Jeanie Bourke - FW: The Inn at Diamond Cove - permit review

From: Barry Yudaken [mailto:yudaken@archetypepa.com]
Sent: Monday, April 15, 2013 12:06 PM
To: David Lloyd; Susan Geffers
Subject: The Inn at Diamond Cove - permit review

CBL: 083E E4600 **Permit ID:** 2013-00436

4/10/2013-JMB/Building:

A3.10

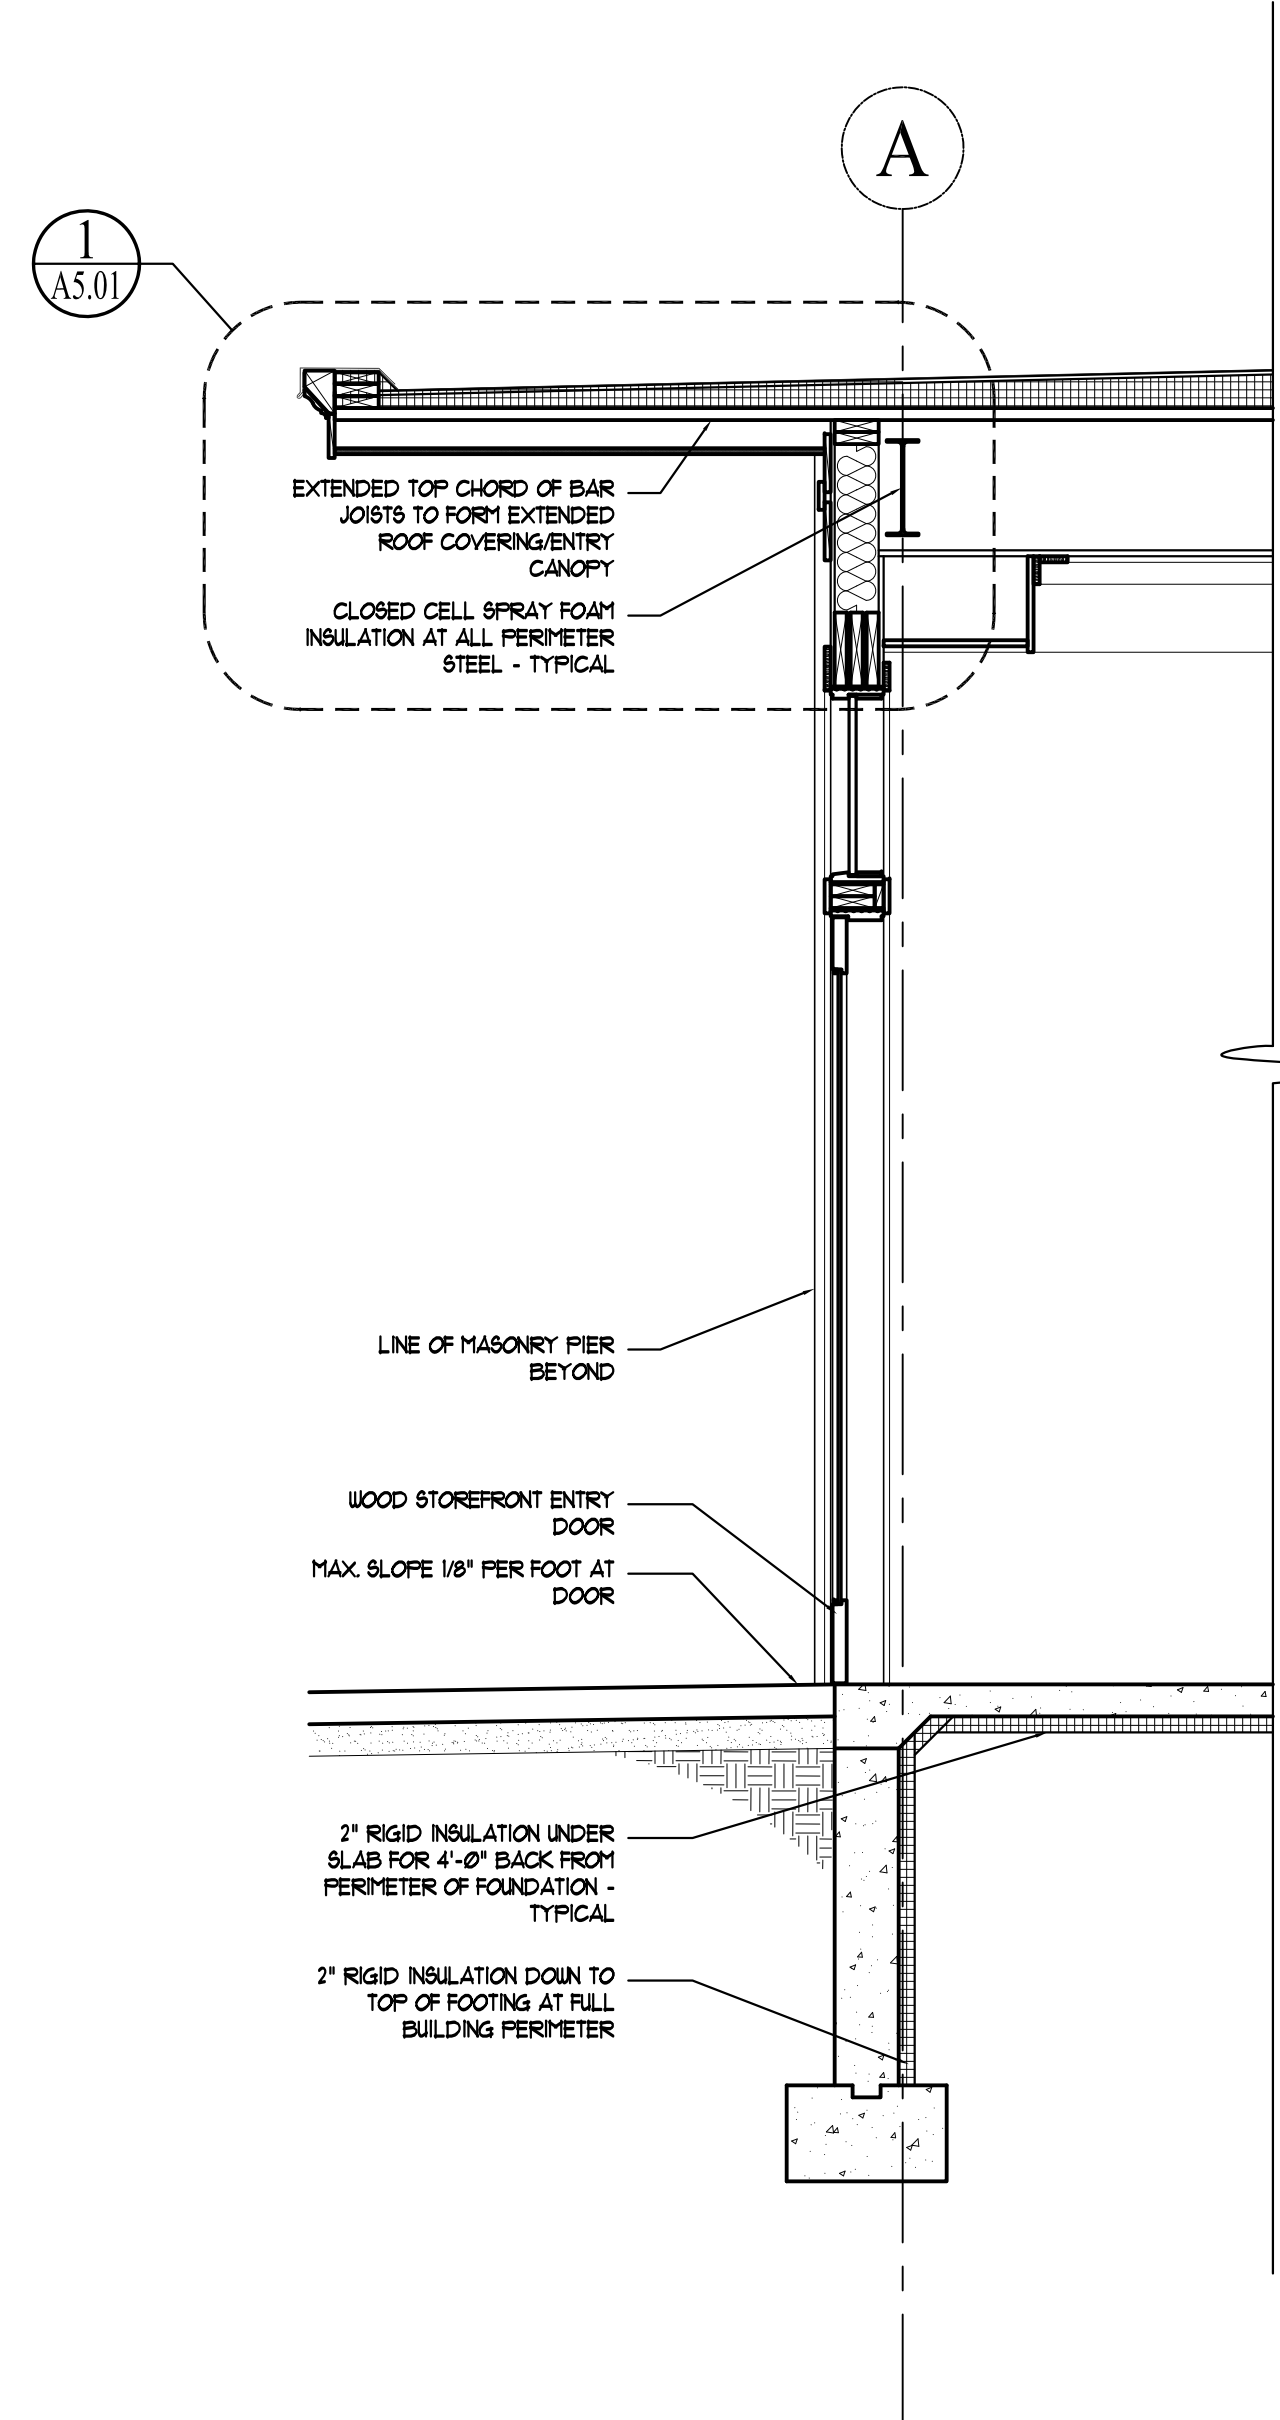
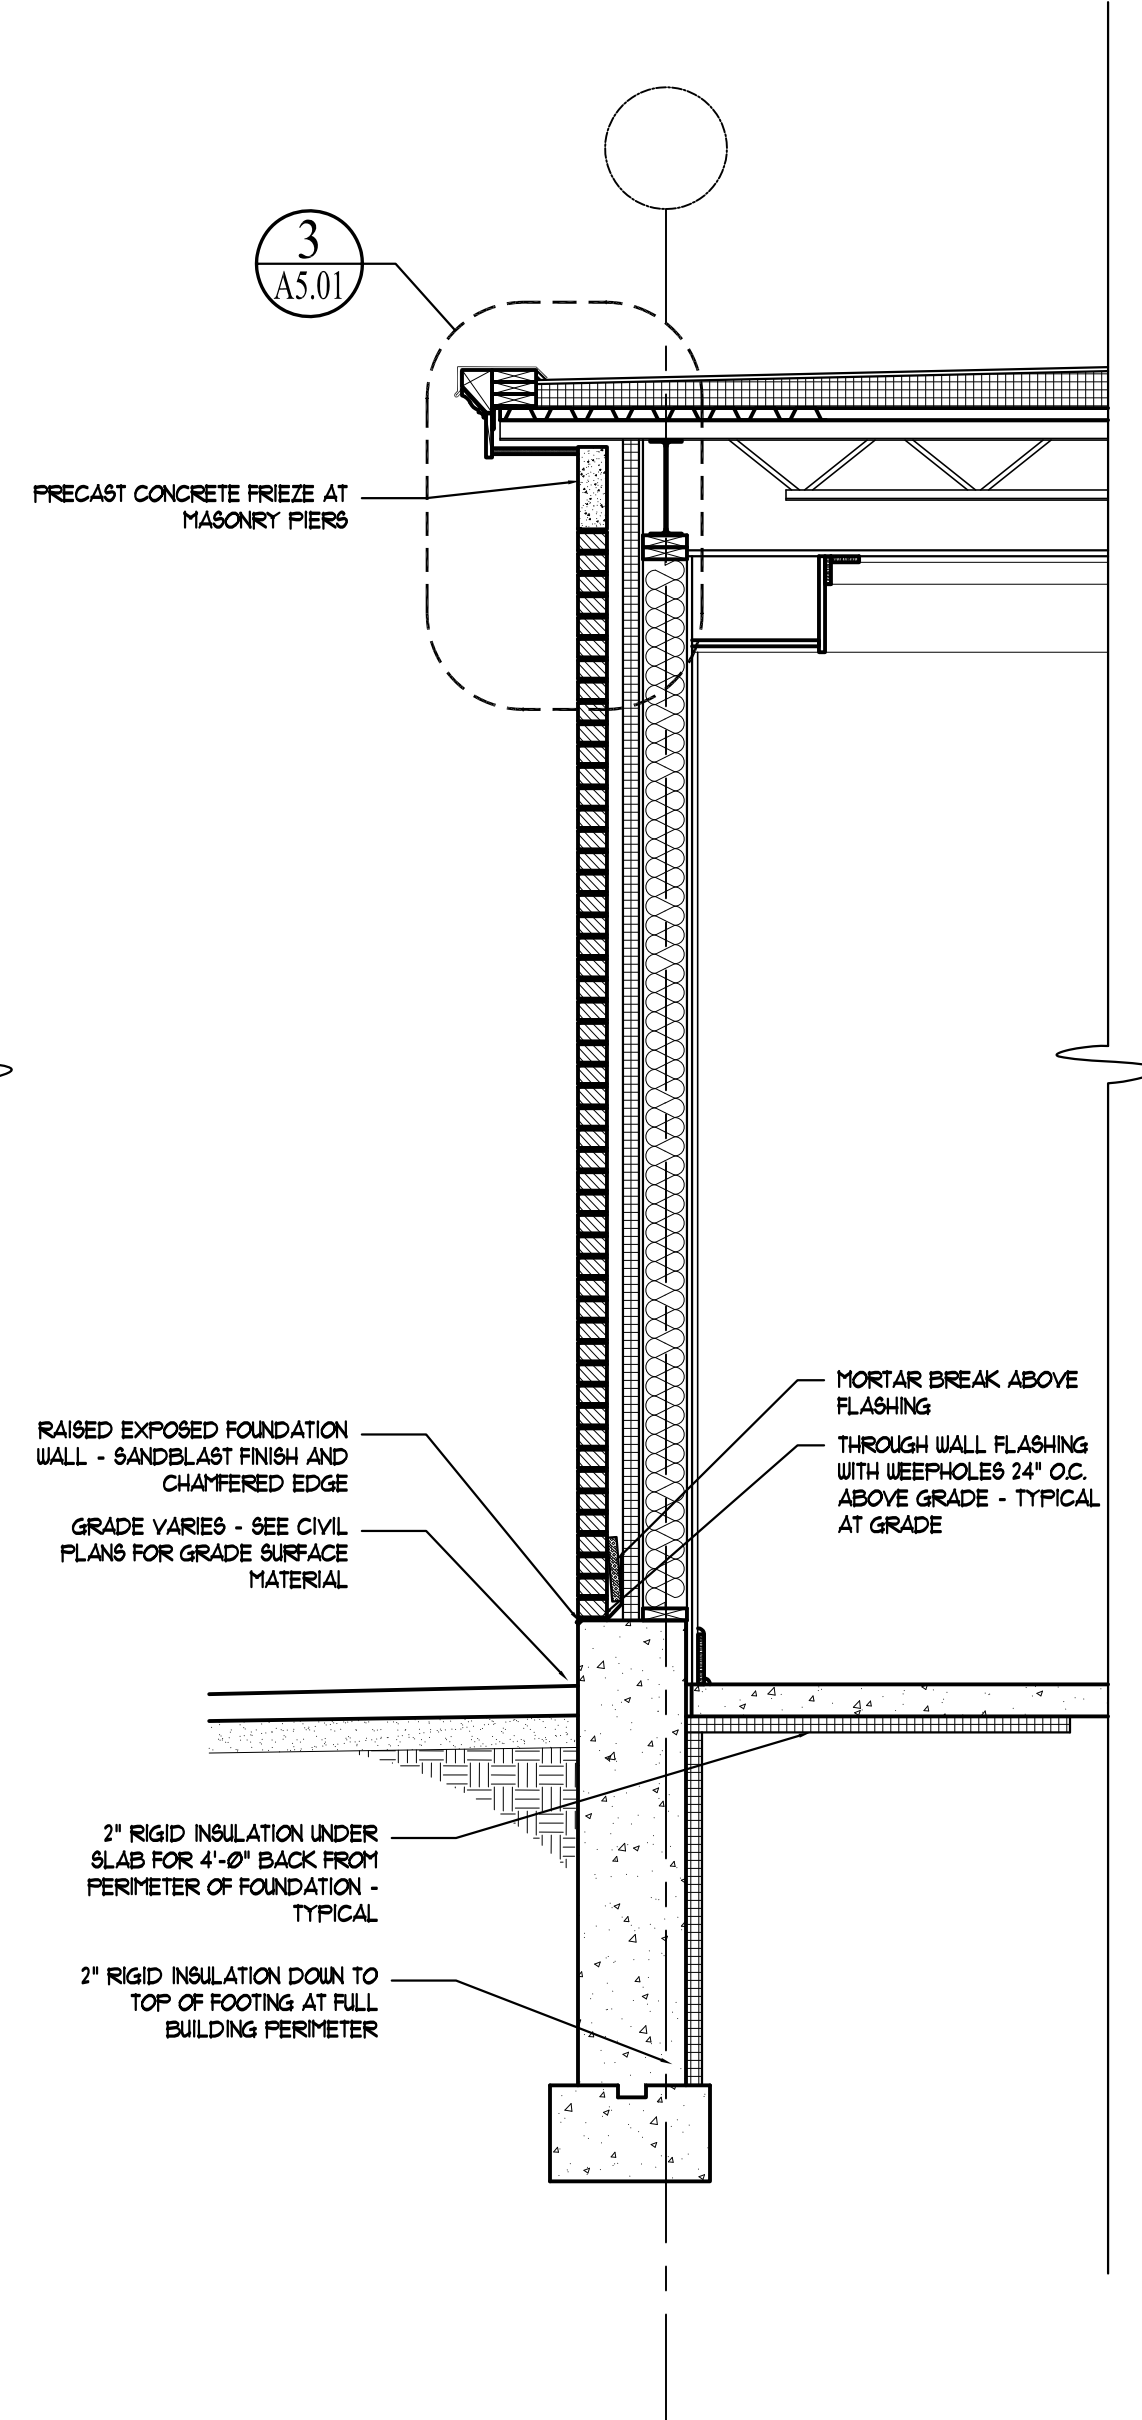
5. Provide tempered window locations per Sec. 2406, **See revised Window Schedule drawing A5.10**
6. Plan A3.10 - wall section - justify the thermal break at the exterior foundation wall from the rigid insulation at grade to the wood framed wall **I don't understand what the problem is with this detail**
